**KIRKLEES METROPOLITAN COUNCIL
INVESTMENT & REGENERATION SERVICE**

**DELEGATED DECISION TO DETERMINE APPLICATIONS FOR
CONSENT, AGREEMENT OR APPROVAL REQUIRED BY CONDITION**

Reference No:	2025/44/91268/W
Site Address:	Land at, Penistone Road, Fenay Bridge, Huddersfield, HD8 0AW
Description:	Discharge of details reserved by conditions 17 (Retaining walls adjacent to highways), 25 (Boundary Treatments), 30 (Retaining Wall Materials) on permission 2022/93154 for erection of 68 dwellings with associated access, parking, open space, landscaping and infrastructure works (including installation of surface water attenuation tank)
Recommending Officer:	Katie Chew

Officer Report

DRAWING TITLE:
1.8m Art. Stone Masonry Wall Detail

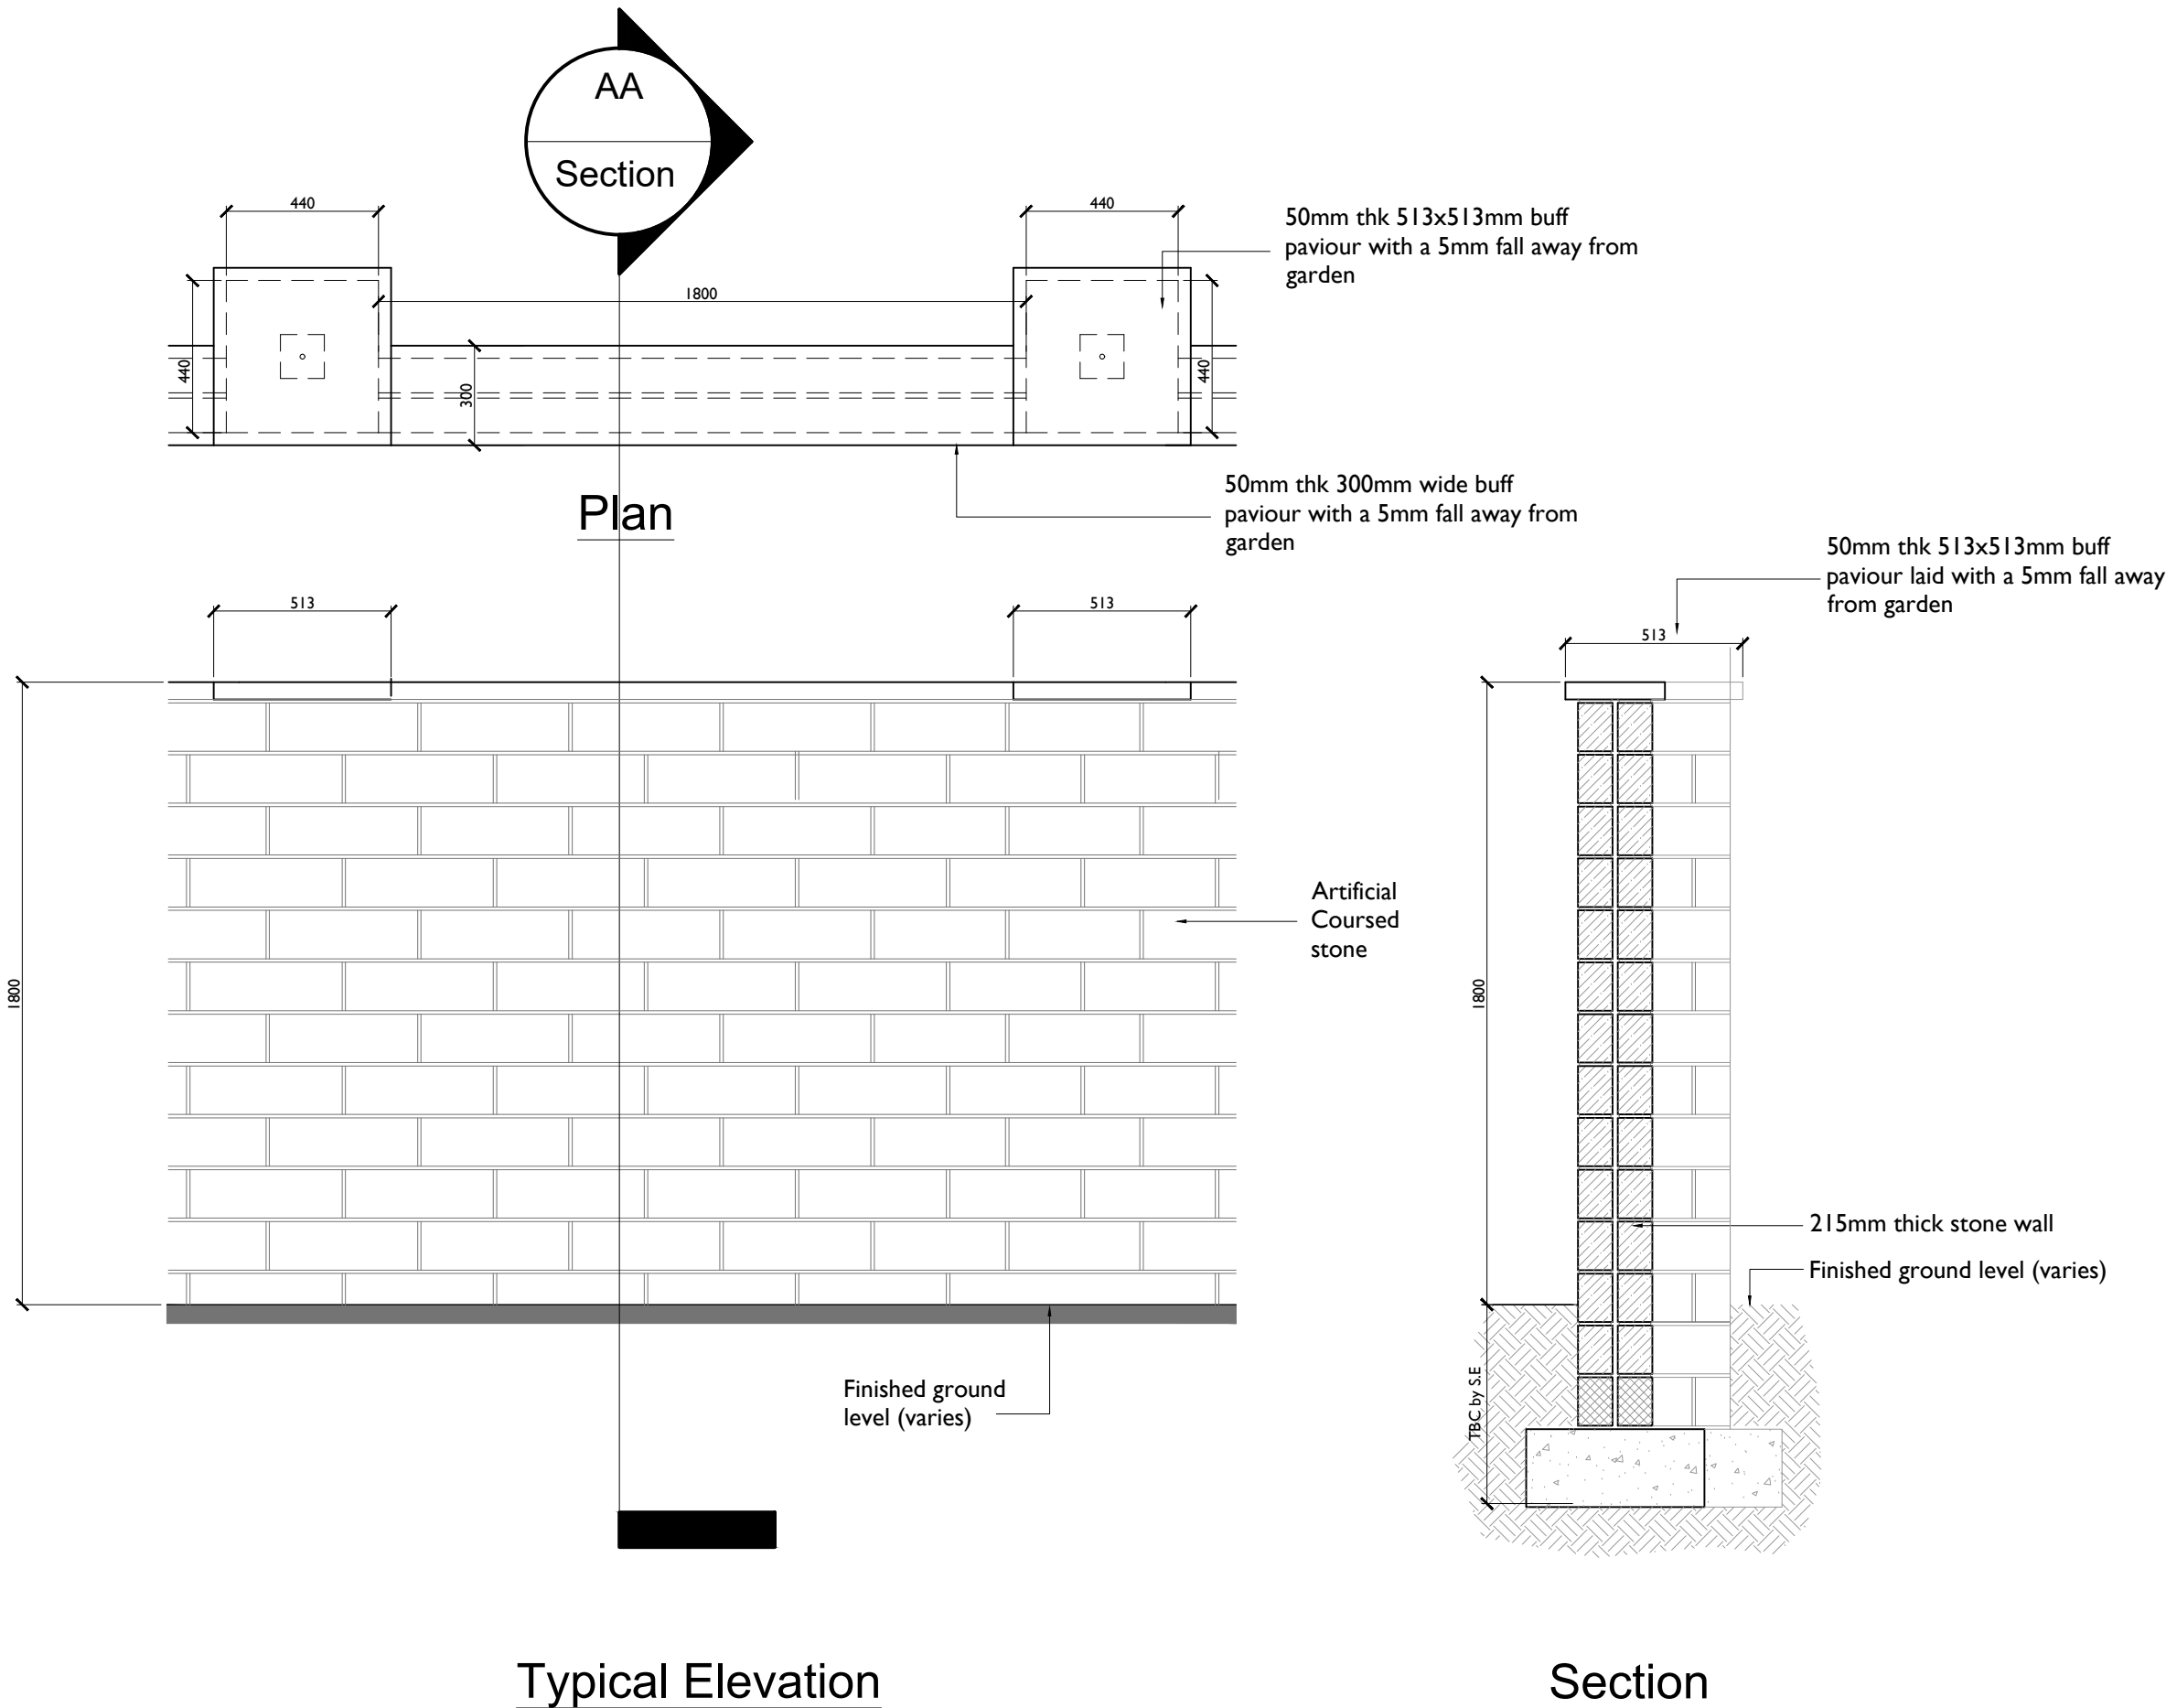
In addition to the above, Drawing No. NH/SD/S120/A/02.01 has been submitted in relation to the 1.8 artificial stone wall. The materials are to include Forticrete Artstone in Premier Regency buff pitched. The location of this boundary treatment and materials are considered to be sympathetic to both the

surrounding area and approved development, and therefore are deemed to be acceptable.
